LOT
Total:
347608.8
Square Feet

ZONE: M

Highway 24

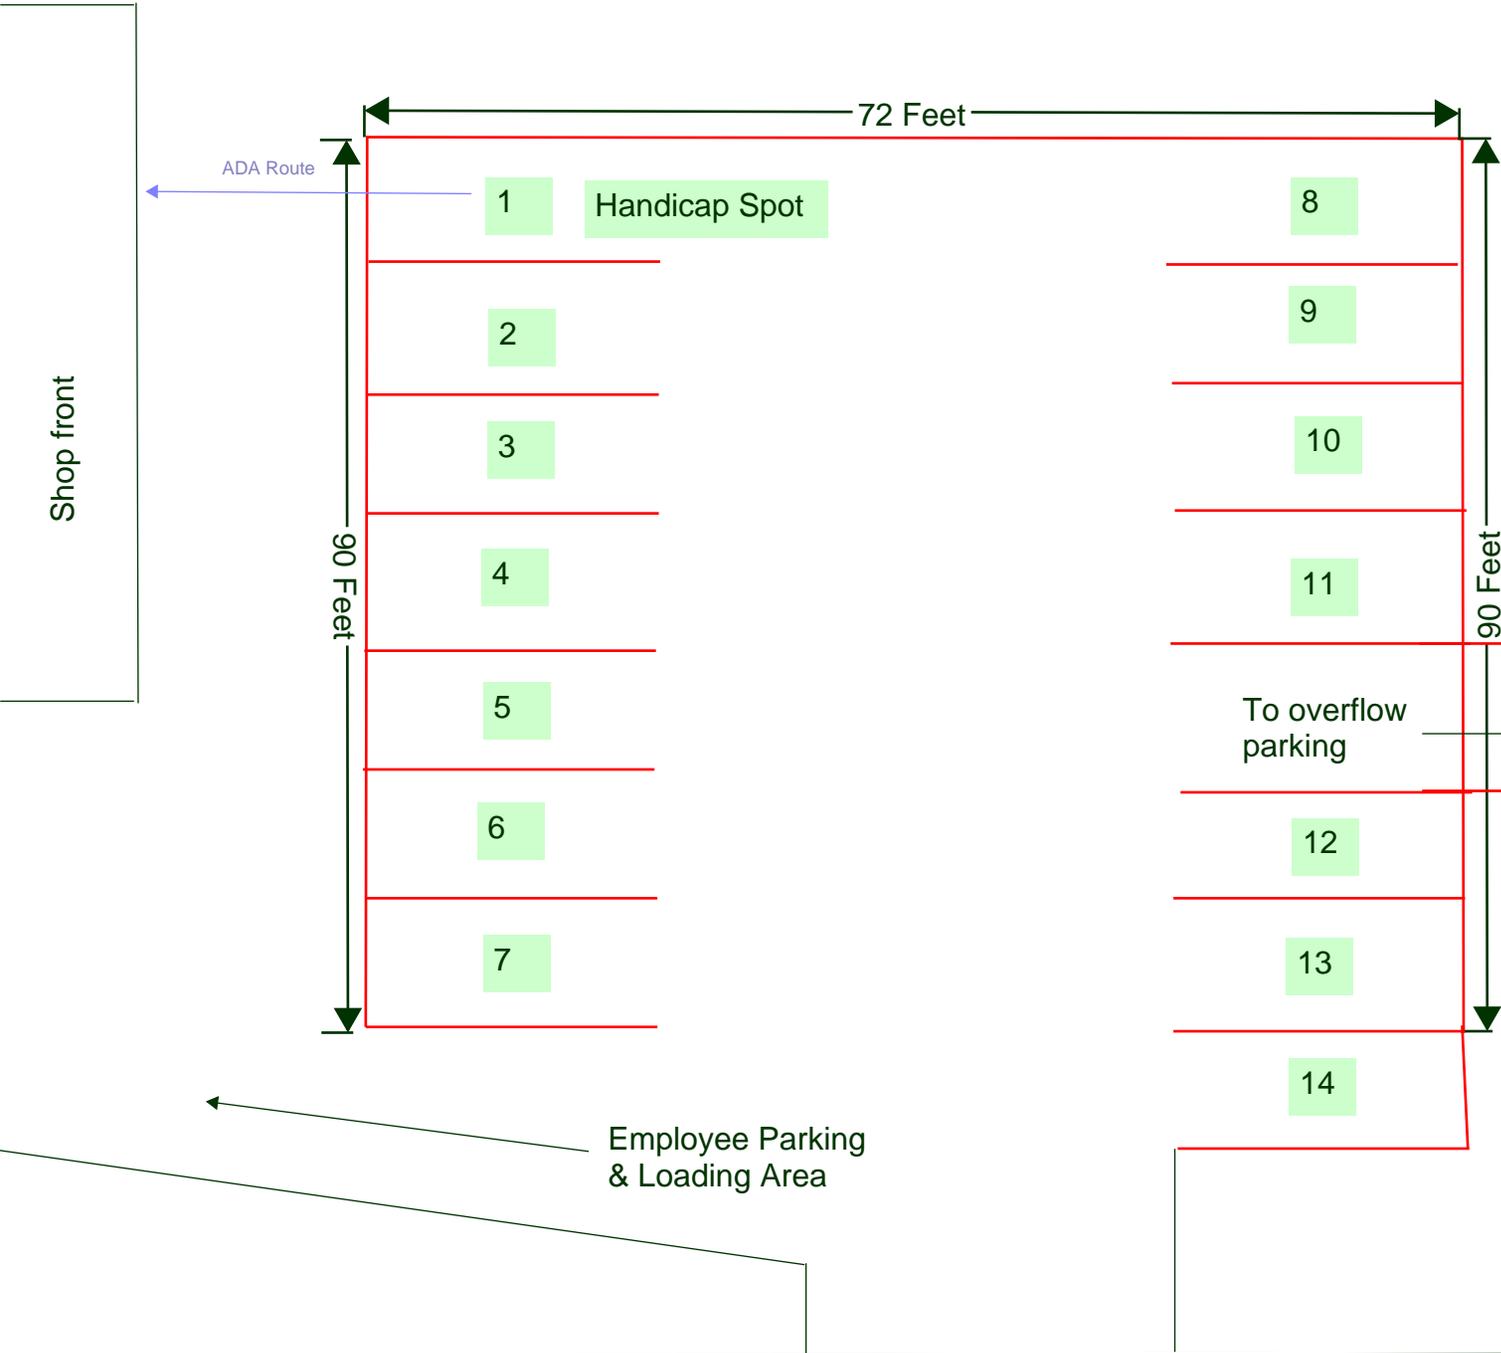
show where the goat area and propane tank are.

show measurement area of parking area

Photos indicate 2 additional trailers and tractor stuff outside of the fence.
